RE: First Christian Church
10101 Montgomery Blvd NE
Request Permanent C.O. - Approved
Engineers Stamp Date 4/1/15 (F21D080)

First Christian Church

DRAINAGE CERT. Appendix

**RE: First Christian Church, 10101 Montgomery Blvd.
Grading and Drainage Plan
Engineer's Stamp Date 4-01-2015 (File: F21-D080)**

FIRST CHRISTIAN CHURCH	DRAWN BY DEM
		DATE J-2015
RICHARD H. DOURTE P.E. # 10854	GRADING & DRAINAGE PLAN CITY OF ALBUQUERQUE	FINAL CHURCH BUILDING
		SHEET # 4 of 6
		JOB # X000X

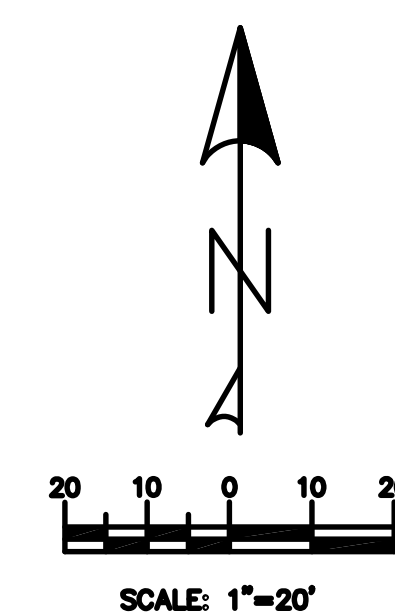
- 1) Show all new improvements that are contributing to the 0.13-acre increase in impervious area on the plan including the patio. Show elevation information for these new improvements.
- 2) For each of the proposed pipe runs, inlets, and sidewalk culverts, show capacity calculations. Label slope and flow that each pipe run is conveying.
- 3) The sidewalk culvert invert elevations and the neoplast area drain invert elevations appear to be 10 feet off. The culvert invert is also higher than the 12" HDPE pipe invert. Double-check these elevations, and revise as needed.
- 4) Label the existing curb and the existing sidewalk width. Call out COA Standard Dwg. 2236 for construction of the culverts. To prevent drop-off situation from sidewalk, extend sidewalk culvert 2 feet behind back of sidewalk. Show transition from 12" pipe to 2 sidewalk culverts.

1. The new improvement area that are contributing to the 0.13 ac area you referenced are included on the attached document. Elevation information is included on the grading plan.
2. The information requested in included on the attached document or on the grading plan.
3. The elevations have been corrected on the grading plan.
4. The sidewalk has been labeled, std dwg drawing has been called out and the detail for the pipe outlet and culvert have been added to the grading plan.

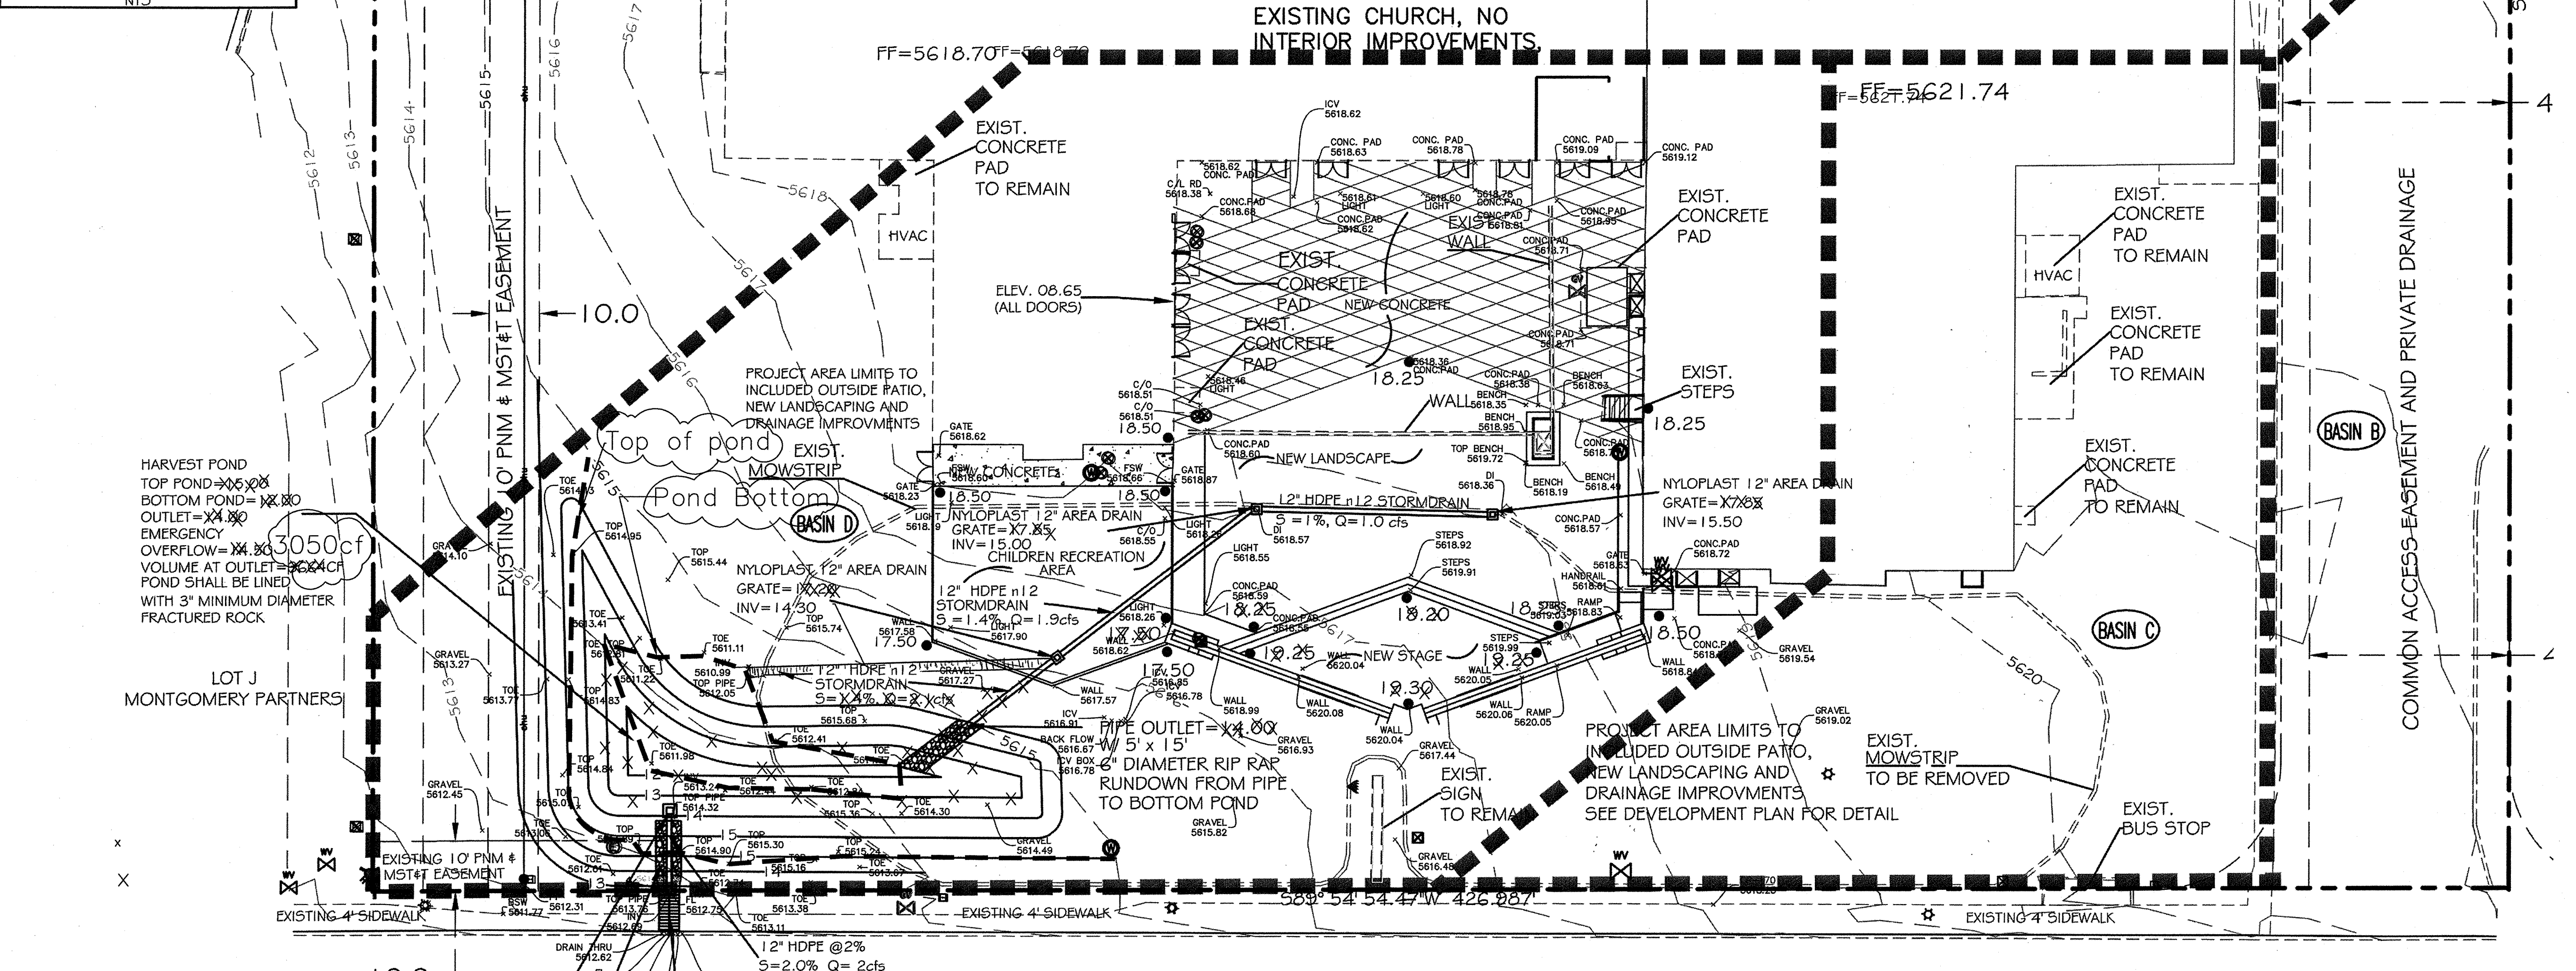
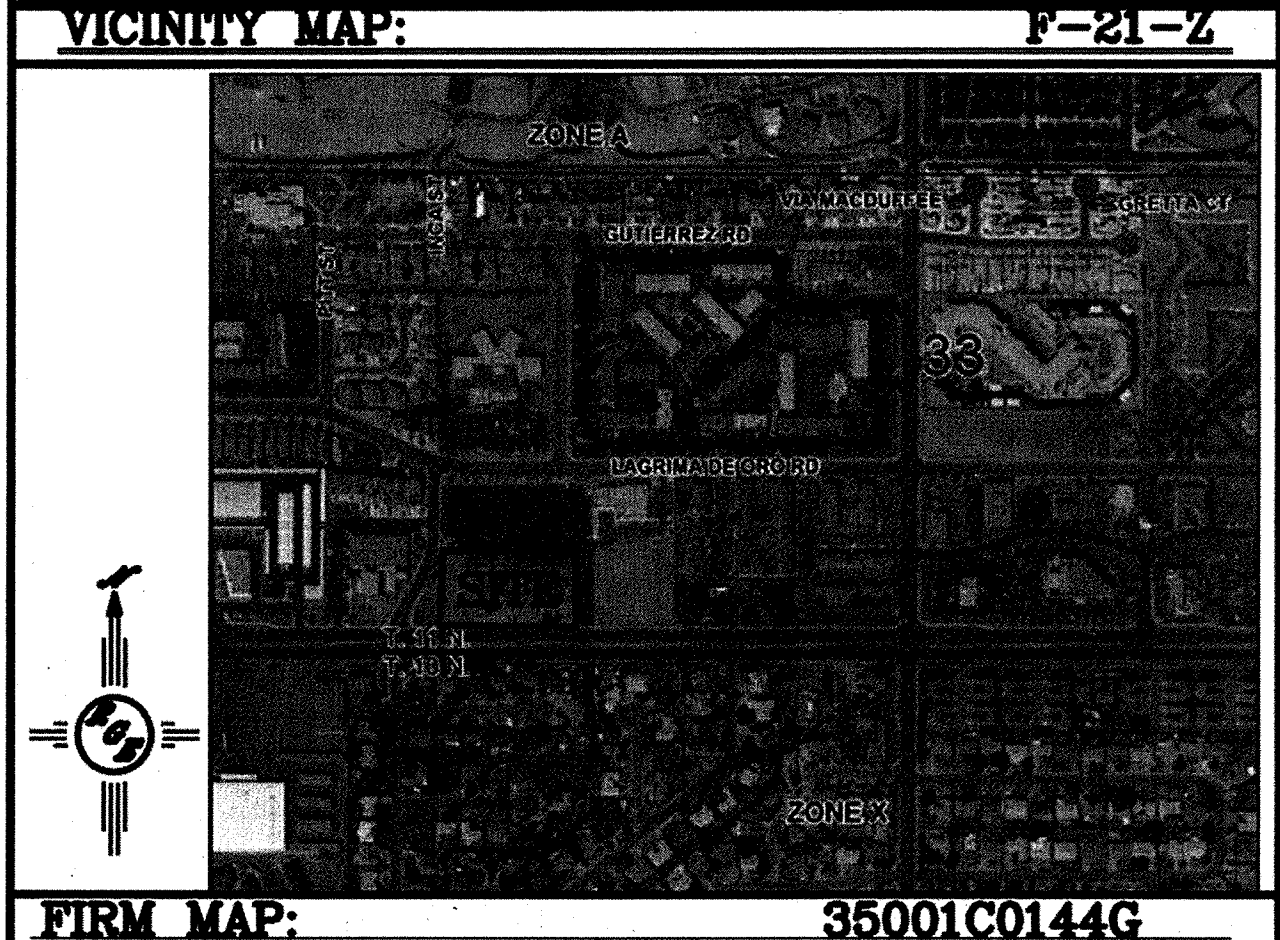
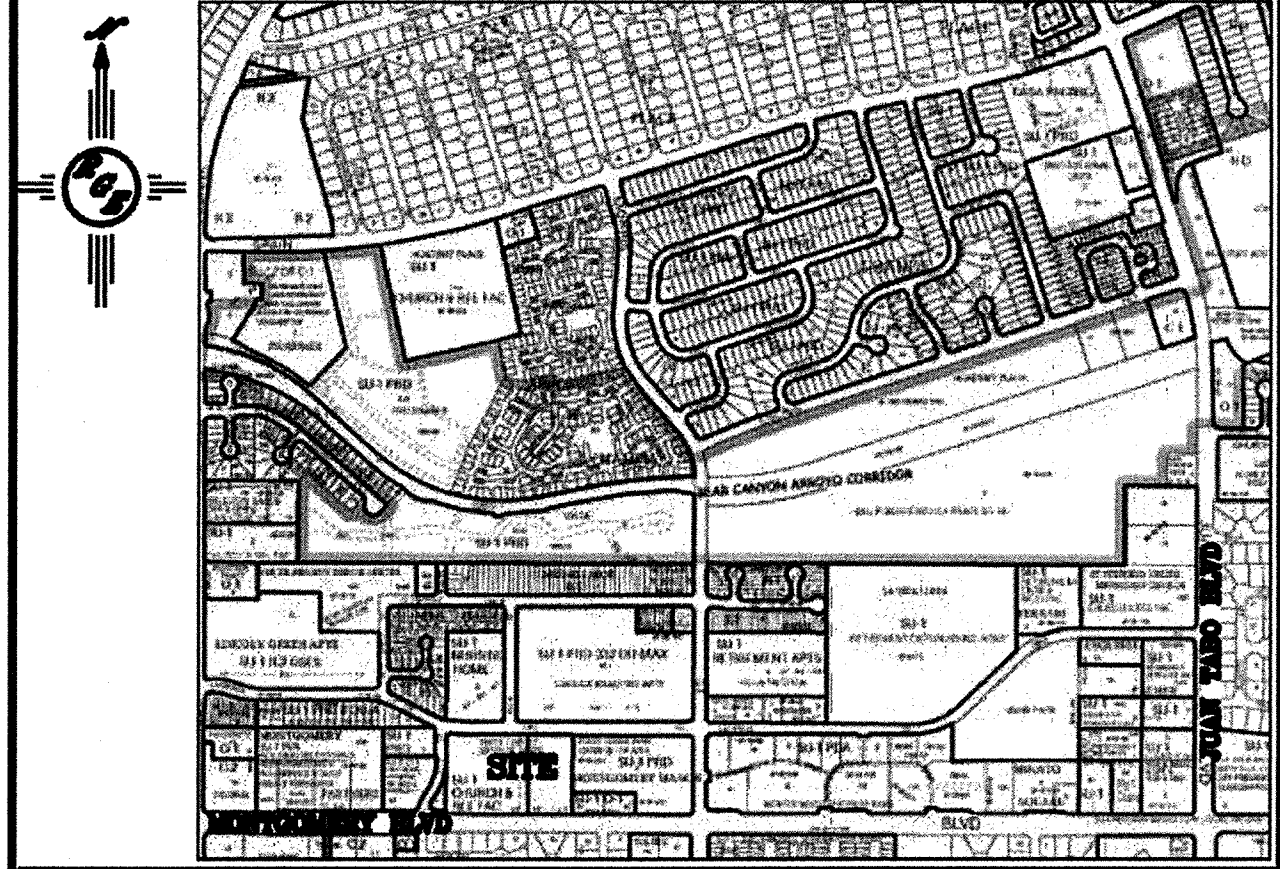
- Two sidewalk culverts were constructed at 17" each instead of 24" each.

Per Francis Equation for rectangular weir

$$Q = 3.33(L - 0.2H)(H)^{3/2}$$

$$L = 17 \frac{1}{2} \text{ in} = 1.42 \text{ ft}$$

$$H = 0.5 \text{ ft}$$

$$Q = 3.33(1.42 - 0.2(0.5))(0.5)^{3/2}$$

$$= 1.55 \text{ cfs each}$$

$$\therefore 2 \text{ culverts} = 2 \times 1.55 \text{ cfs} = 3.1 \text{ cfs}$$

The capacity of the Pond outlet pipe is 2 cfs, Therefore the two 17" culverts at 3.1 cfs are adequate.
